# CITY OF ALBUQUERQUE

**Re: Snow Vista Self Storage**  
**9850 De Vargas Rd SW**  
**Conceptual Traffic Circulation Layout**  
Engineer's Stamp 09-26-23 (M09D012B)

The conceptual TCL submittal received 09-27-23 is approved for DHO and/or DFT submittal. When submitting this project through the building permit process, a full Traffic Circulation Layout will need to be submitted and approved prior to building permit.

<p>RONALD R. BOHANNAN P.E. #7868</p>	98TH & SAGE STORAGE ALBUQUERQUE, NM CONCEPTUAL TRAFFIC CIRCULATION LAYOUT	DRAWN BY BF
		DATE 09/19/2023
	<p>TIERRA WEST, LLC 5571 MIDWAY PARK PLACE NE ALBUQUERQUE, NM 87109 (505) 858-3100 www.tierrawestllc.com</p>	SHEET # TCL-1
		JOB # 2023018

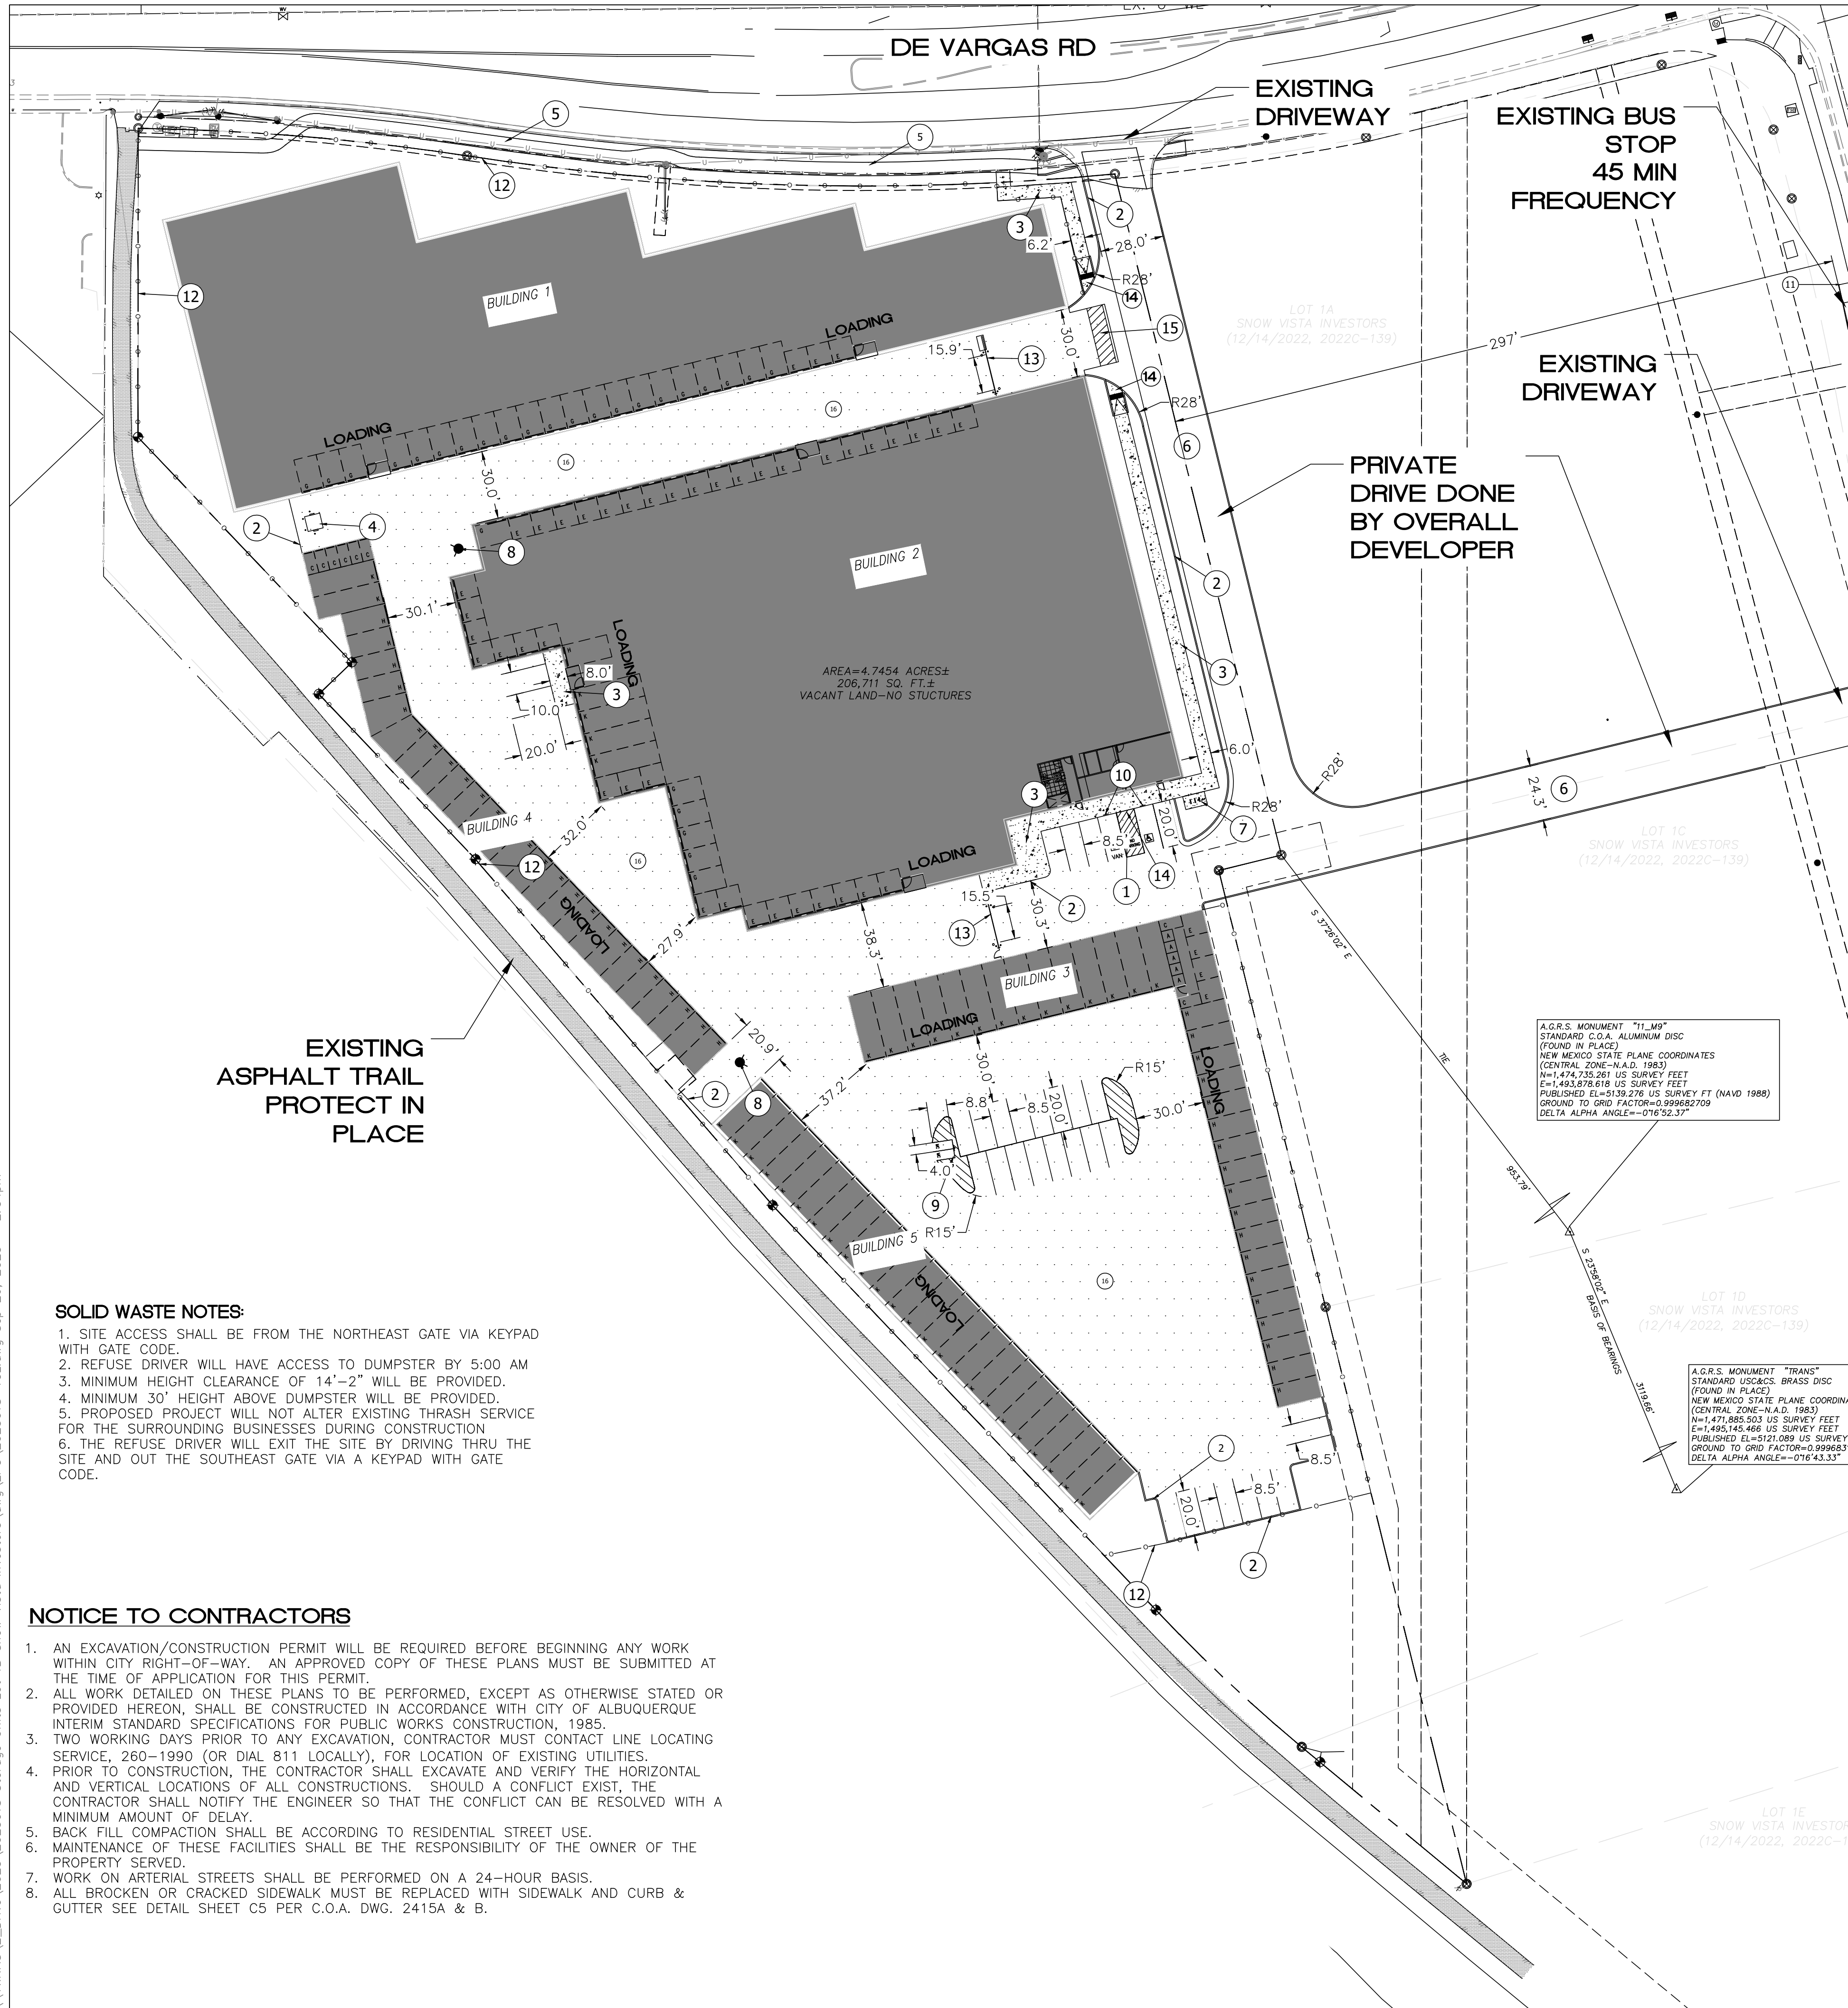
1. It is not uncommon for projects with 5 buildings for the buildings to be built at different times (phased). If this project is to be phased, please indicate this and include the associated parking with each phase.

2. The TCL uses building numbers, while the Fire One Plan and the Solid Waste plan use letters. They should both use numbers or both use letters to facilitate the building permit/CO process.

3. The TCL shows the access width through the gate of 15.9 feet (N) and 15.5 feet (S) and the Solid Waste plan shows the access width to be 15 feet 2 inches. The Fire One Plan appears to show an access width of 26 feet.

All plans should have the same dimension. If the Fire One Plan is revised to clarify this dimension, then provide the approved revised Fire One Plan.

4. Please clarify the office location.

5. It does not seem pertinent to specify "Private Drive done by Overall Developer" as the drive is needed to support the buildings.

6. Show the access easements and provide the plat or shared access agreement.

7. The parking/curb line at the south end on the site plan is different than the fire one plan, solid waste plan and grading plan. How is it to be configured?

8. Provide three bicycle parking spaces.

11. Provide the radius for the "ends" (3 feet) of the parking islands.
12. Show the entire private drive out to Snow Vista Blvd.

ACCESSIBLE PARKING SIGN

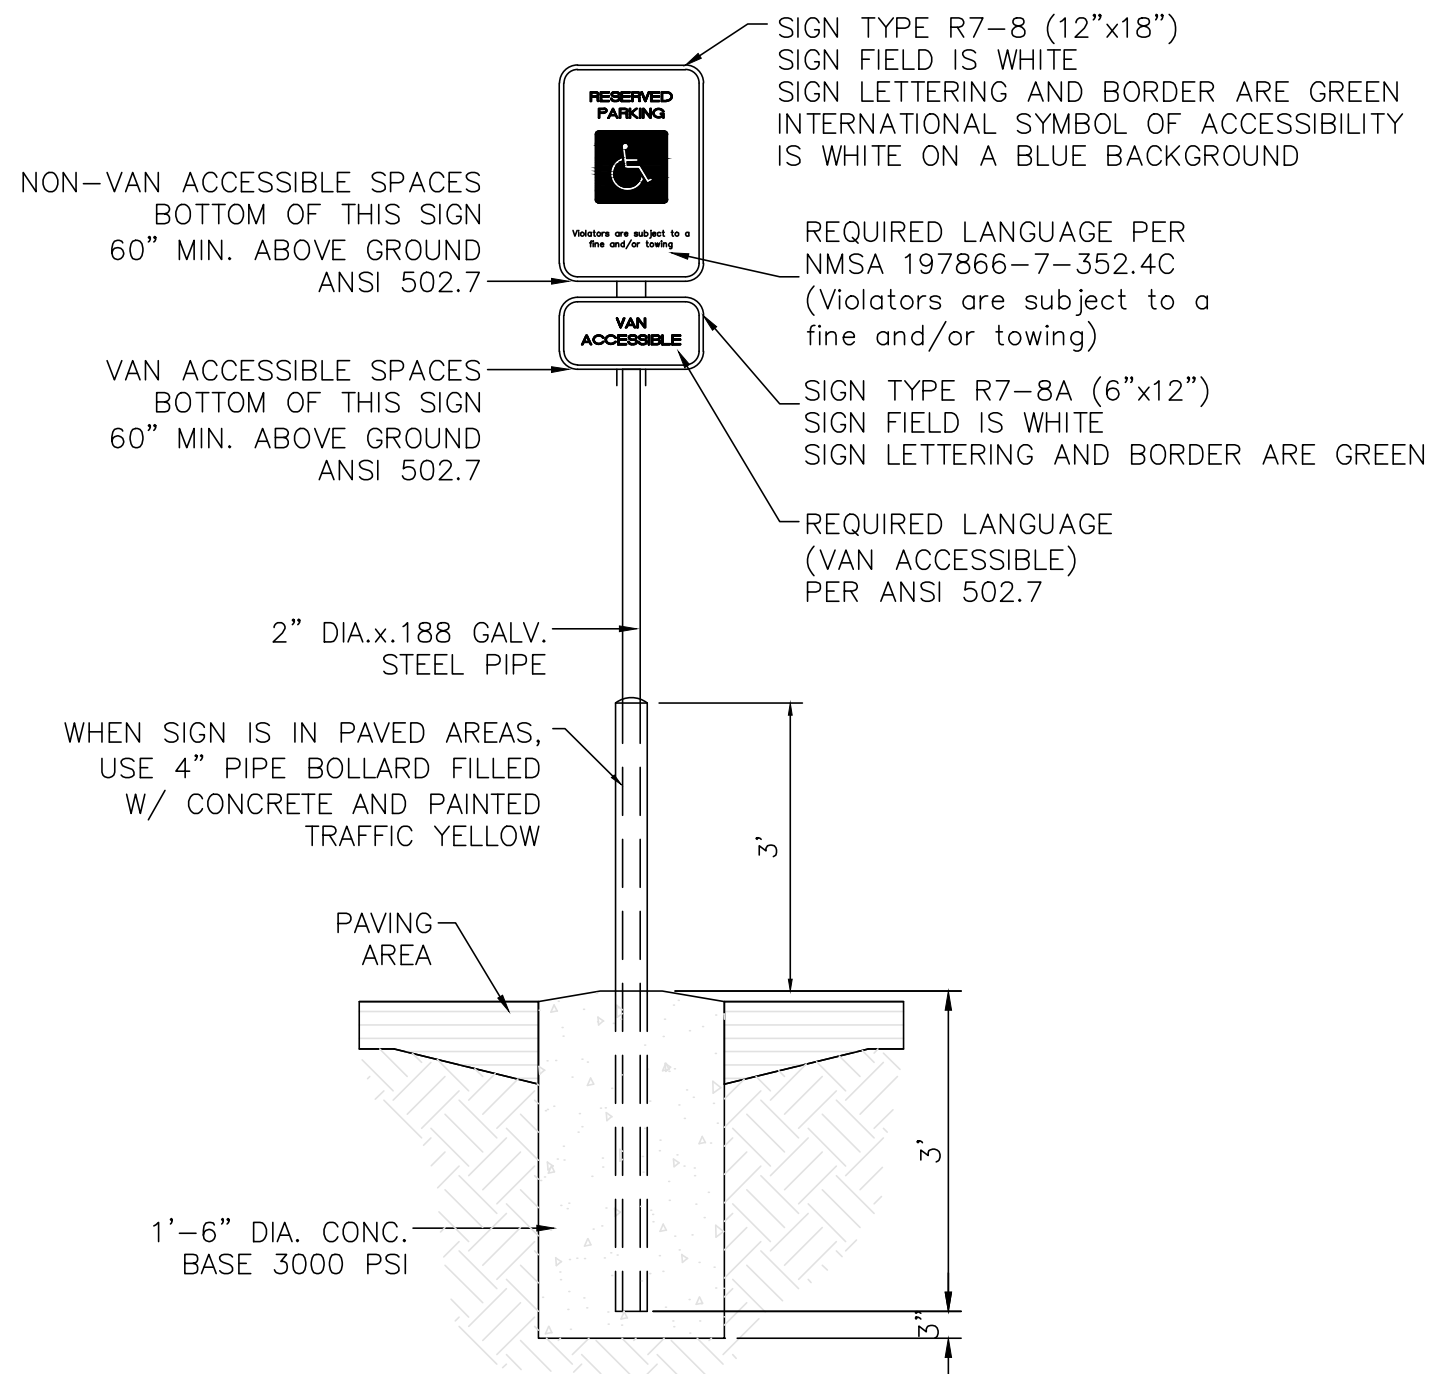
10. Please remove the redundant Accessible Parking Sign detail.
